Meridian Ranch Sketch Plan  
2017 Amendment  
Traffic Impact Analysis  
(LSC #174350)  
July 7, 2017

RE: Meridian Ranch Sketch Plan  
2017 Amendment  
El Paso County, CO  
Traffic Impact Analysis  
LSC #174350

Sketch Plan

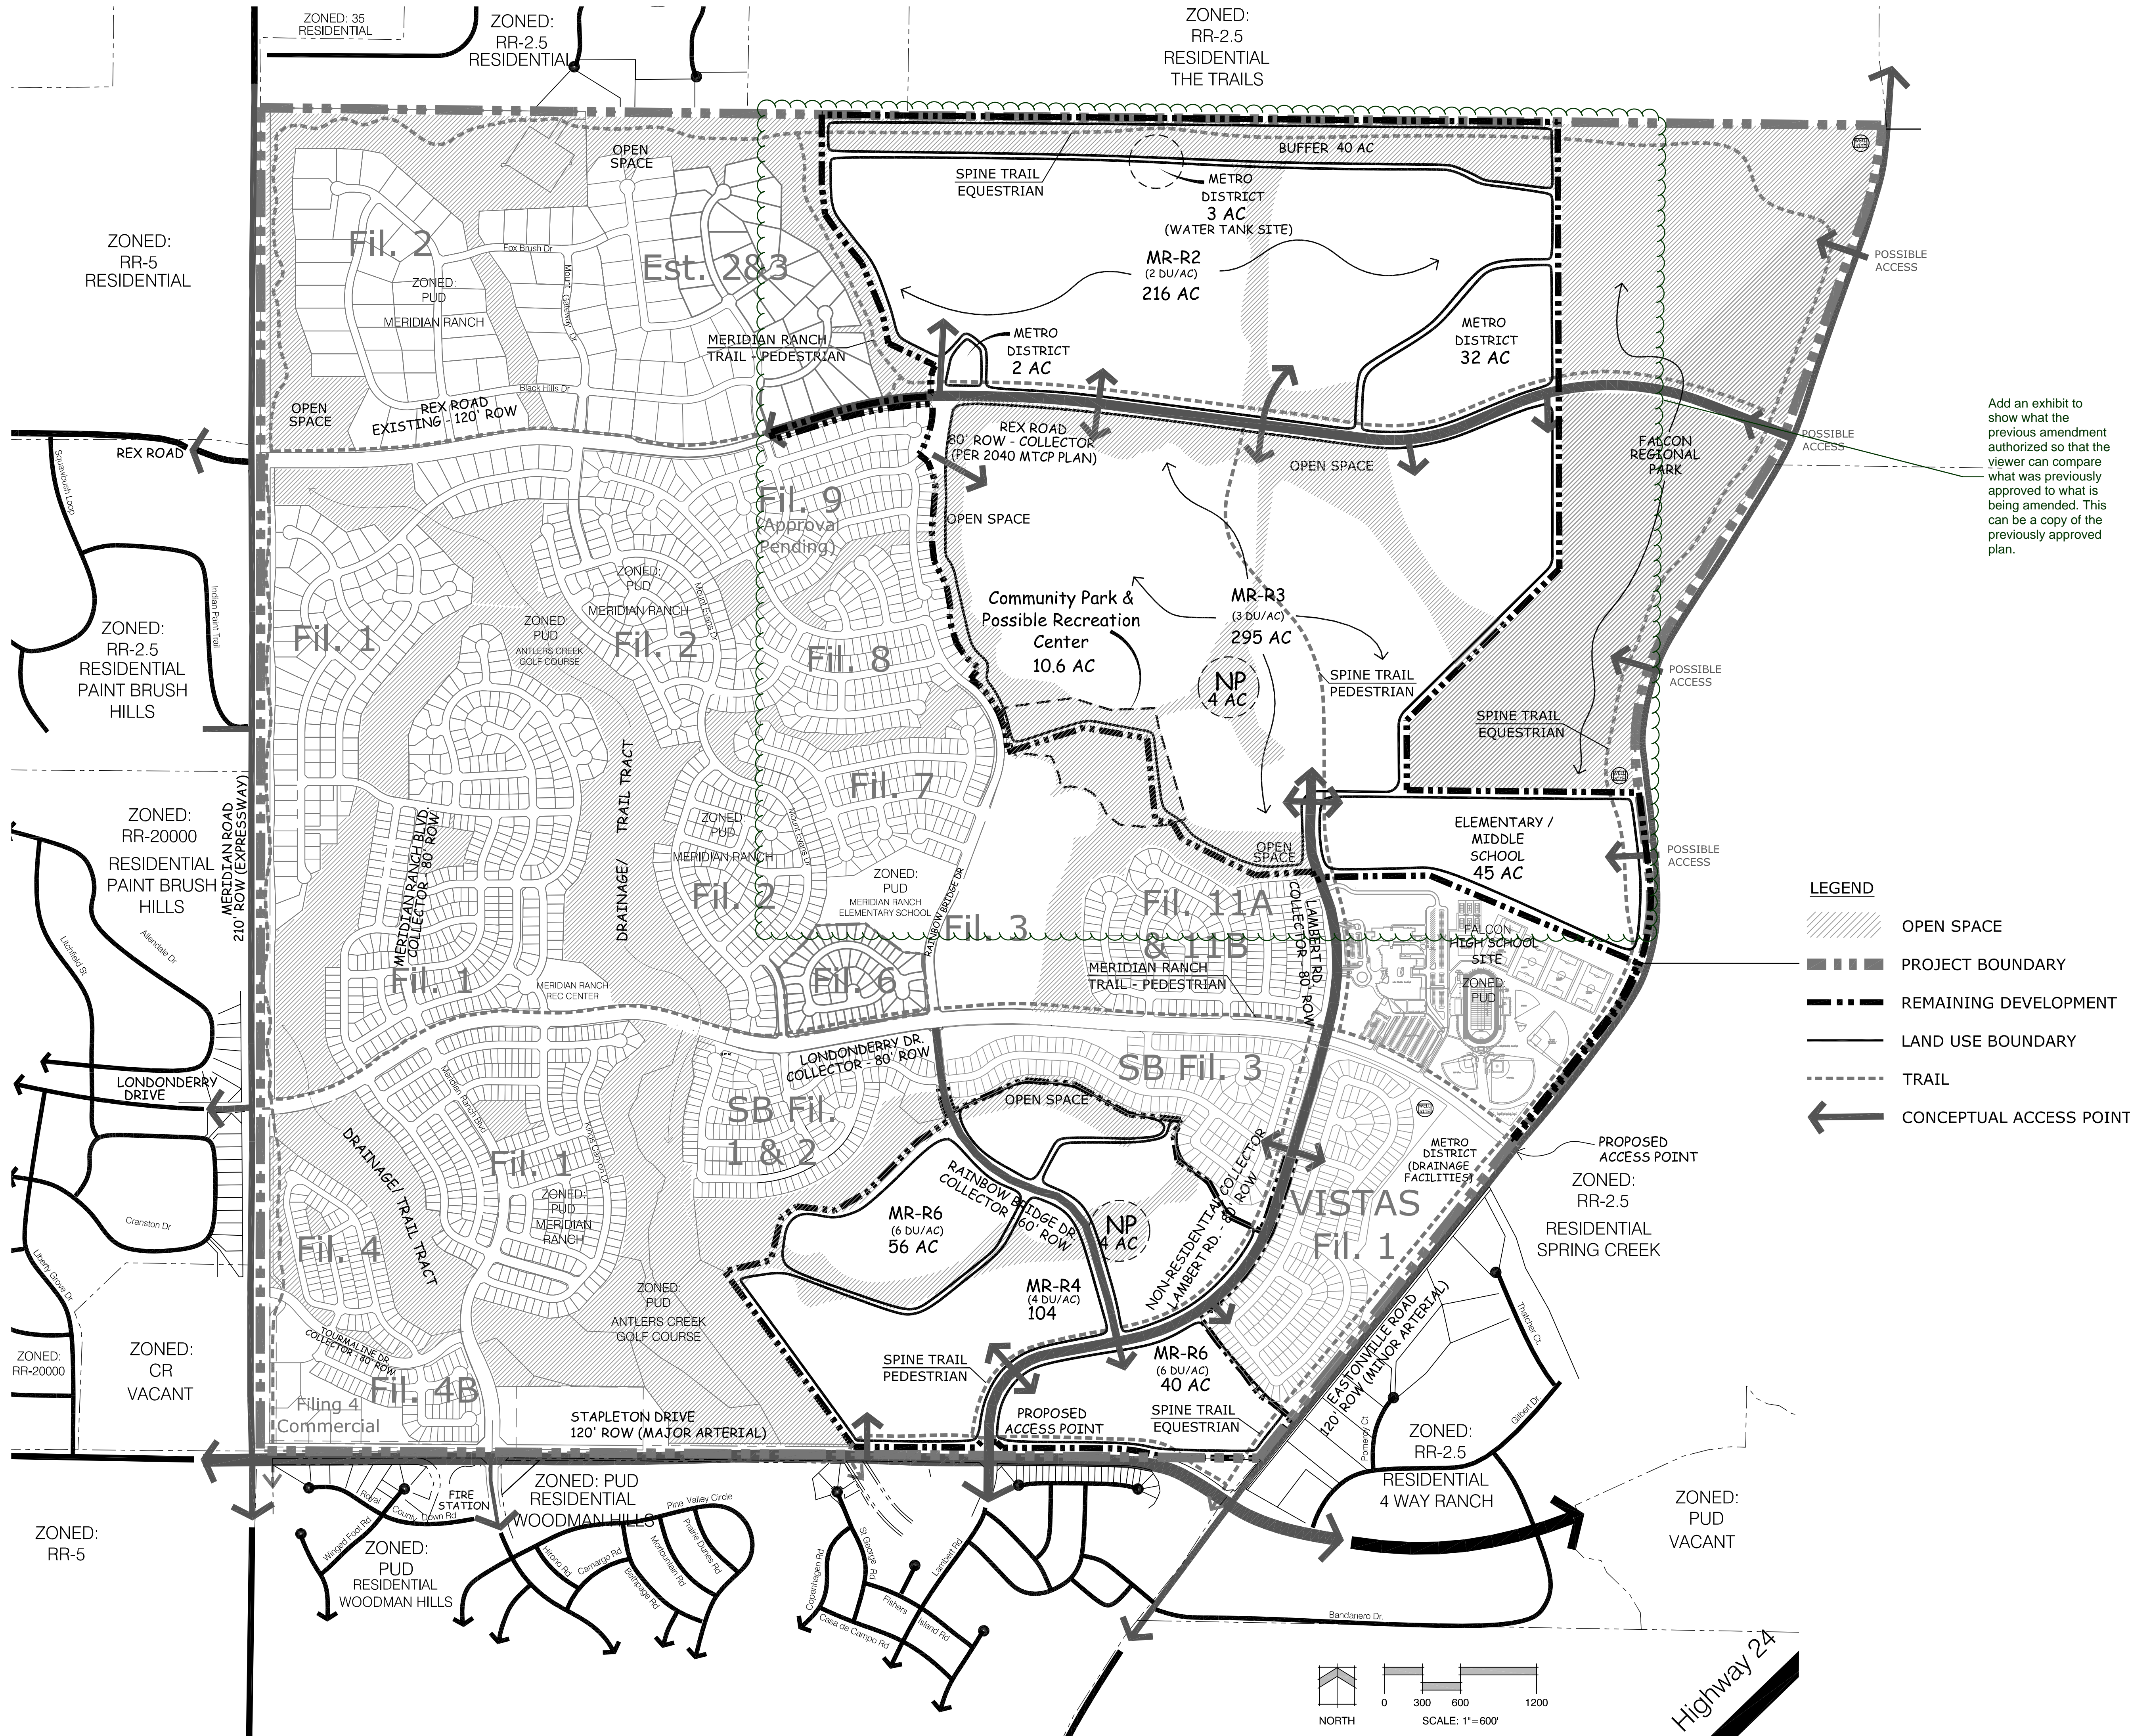
The totals do not match the sketch plan amendment. Update this or the sketch plan so the numbers match.

The highlighted area is what's show being amended in the proposed sketch plan. Update the study and exhibits accordingly.
